Subject: RE: AL/54/21/DOC - Forge House - URGENT REQUEST FOR CONSERVATION COMMENTS PLEASE!

AL/54/21/DOC

Forge House Nyton Road Westergate PO20 3UP

Approval of details reserved by condition imposed under ref APP/C3810/W/18/3213581 (AL/129/17/PL) relating to Condition No 4 - materials & finishes.

**External Walls:** Flint Blocks.

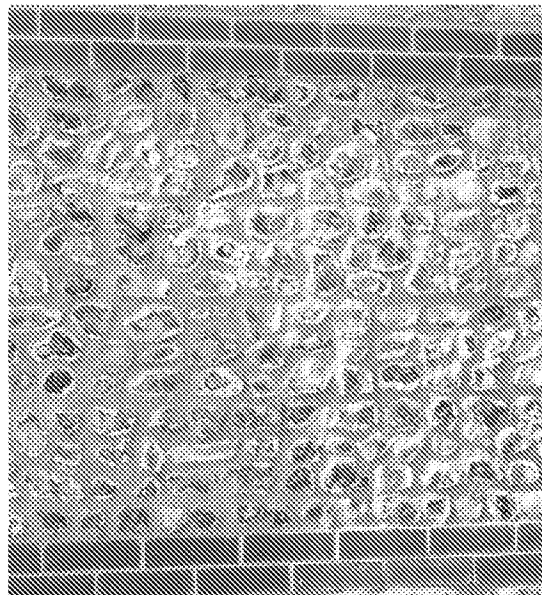
The materials would appear to reflect those in the local area. I note that the intention is to use Dorset Flint and Stone Blocks Ltd: Knapped field flint. This is unfortunate, as it is normally possible to view the coursing of the larger cementous blocks that are used to construct the walling. This would detract from the other walling on the site.
